Callaghan Engineering

REVIEW OF THE INFORMATION SUBMITTED BY THE APPLICANT ON THE TOPIC OF MAJOR ACCIDENTS IN RELATION TO PLANNING APPLICATION REF: ABP-304433-20

REPORT

DOCUMENT NO.	N/A	STATUS	N/A
DOCUMENT TITLE	REPORT		
DISCIPLINE	<input type="checkbox"/> ELEC <input type="checkbox"/> MECH <input checked="" type="checkbox"/> PROC <input type="checkbox"/> INST		
ORIGINATOR	PEDRO RIVERA	DATE	8 JULY 2021
PROJECT TITLE	INDAVER PROJECT ASSESSMENT		
PROJECT NO	21-006		
CLIENT	AN BORD PLEANÁLA		
CLIENT SITE	N/A

1 PROPOSED TANK FARM LAYOUT
SCALE: 1:50 @A1

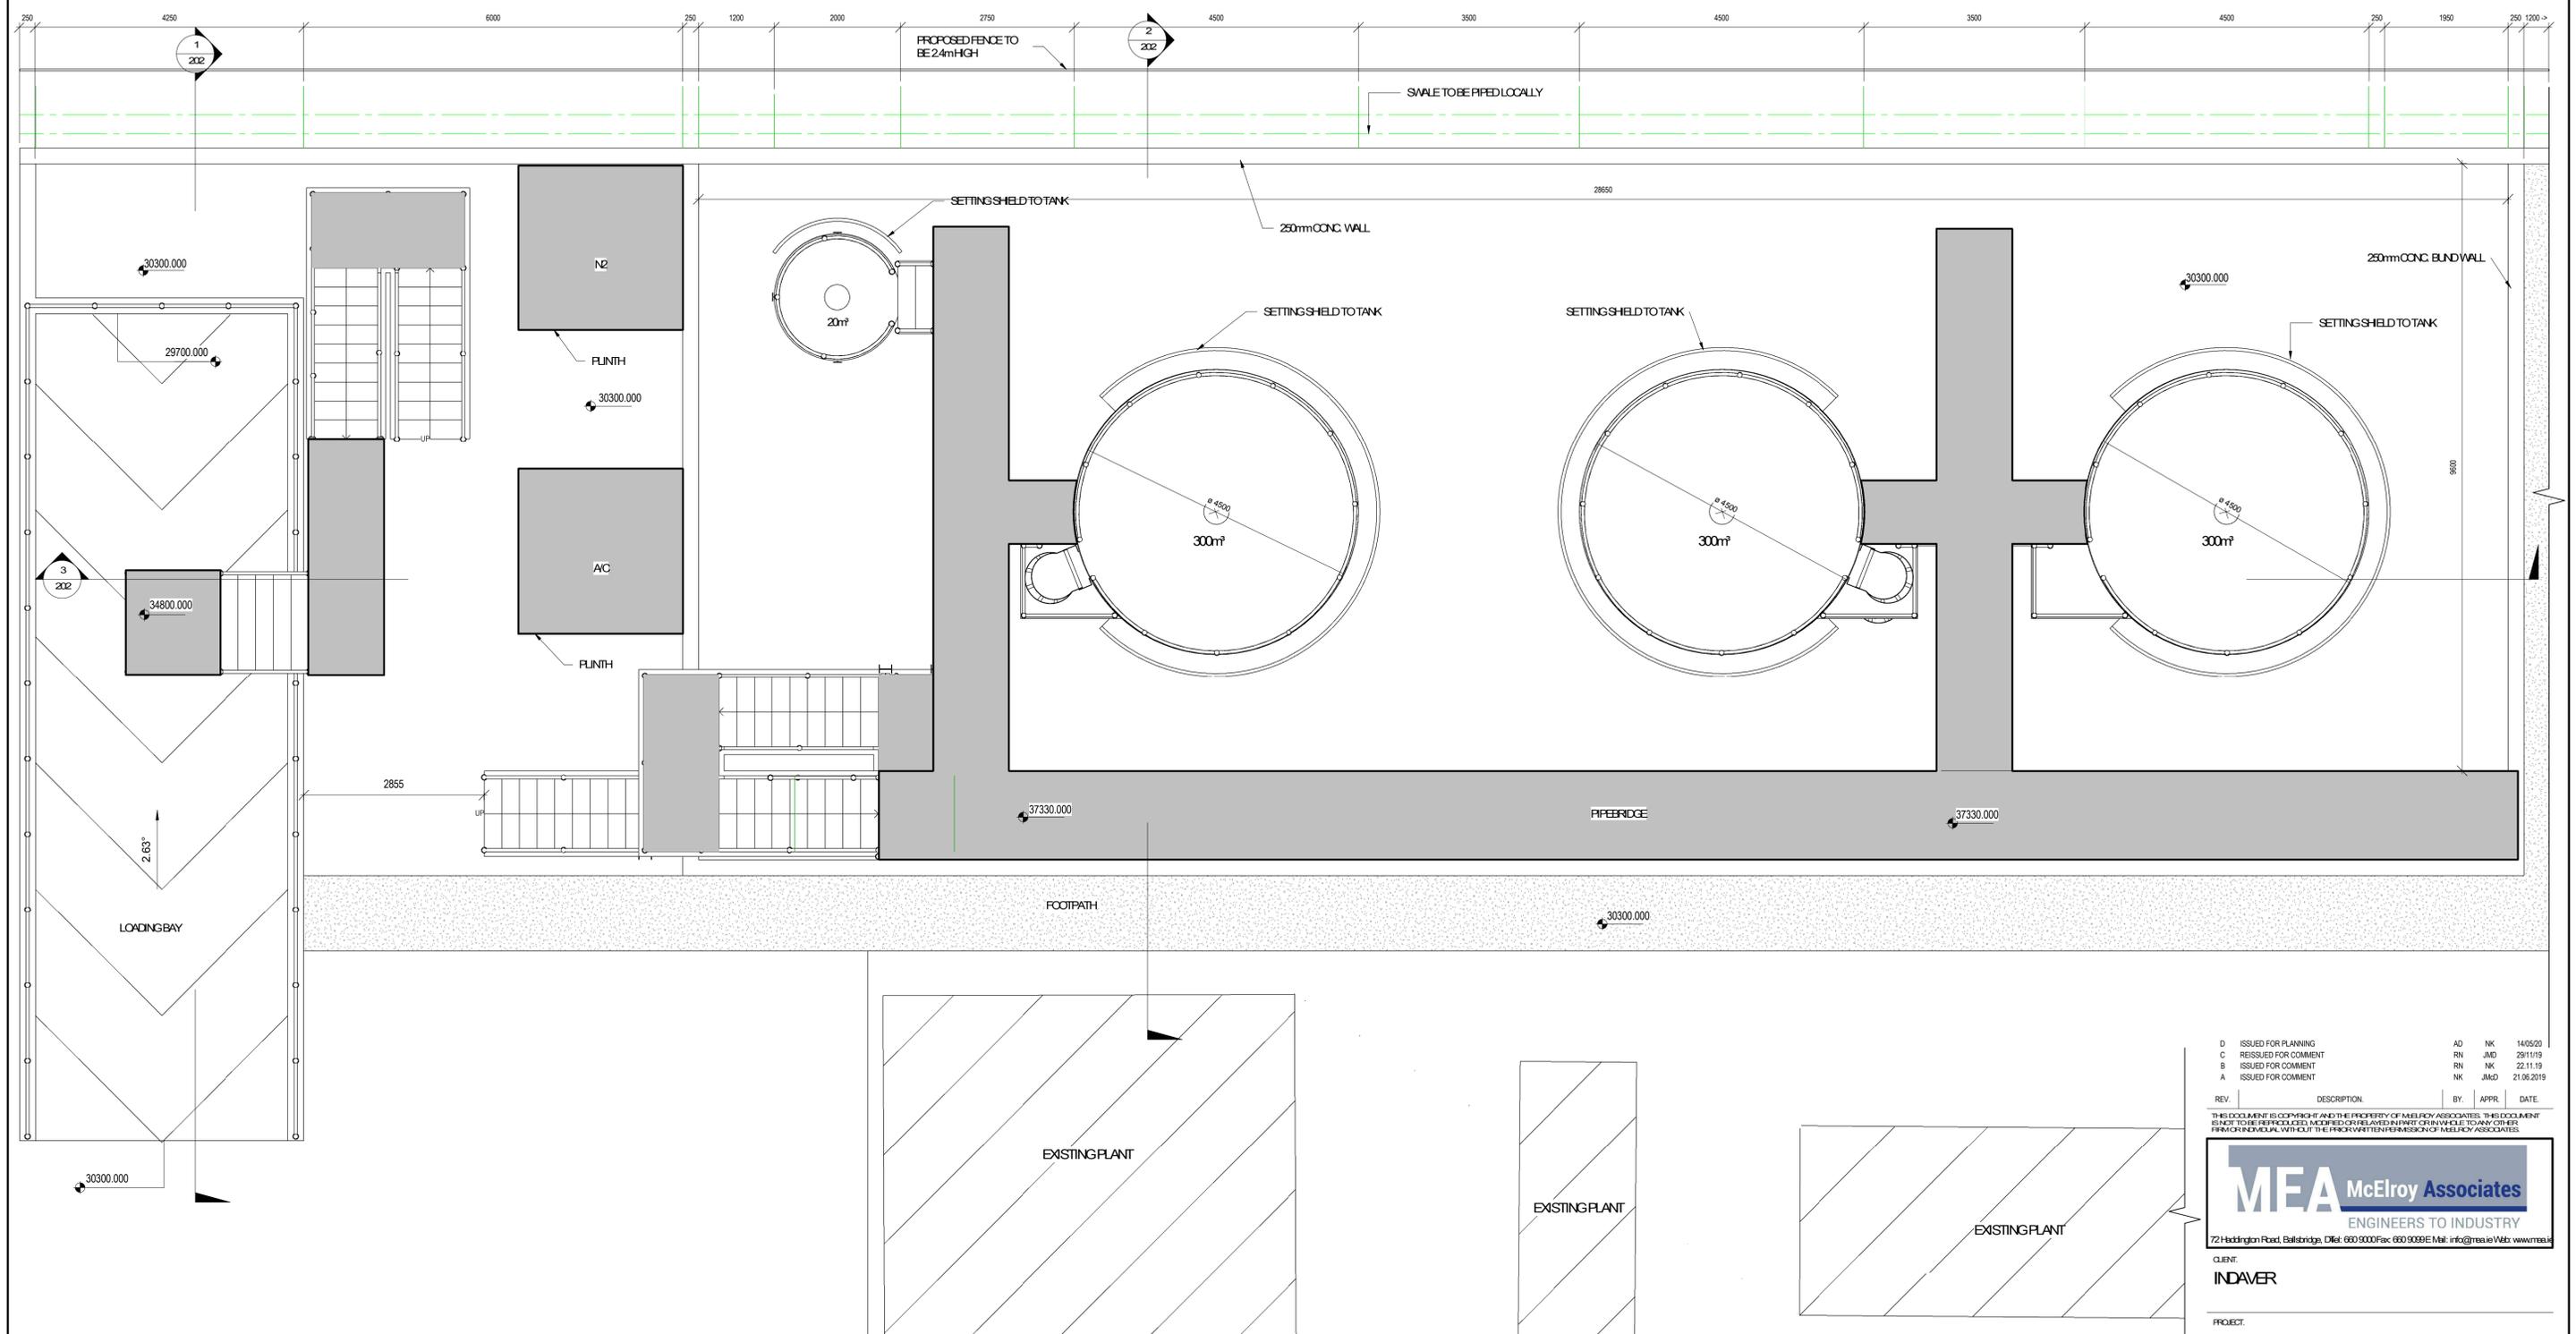
In relation to the aqueous tank farm, the applicant has confirmed that the tanks will be designed in accordance with API 620 "Design and construction of large, welded, low-pressure storage tanks". This is

an appropriate standard for the aqueous farm tanks design. While not specifically stated in the submission, it is important that the venting system will cover the bund fire scenario described as anticipated worst case.

As the risk of an aqueous bund fire is identified as the worst-case credible event for the new tank farm, the applicant shall design the tank farm catering for the fire case scenario as part of the design criteria, including the provision of adequately sized emergency relief venting and any other safety measures deemed appropriate to mitigate risk.
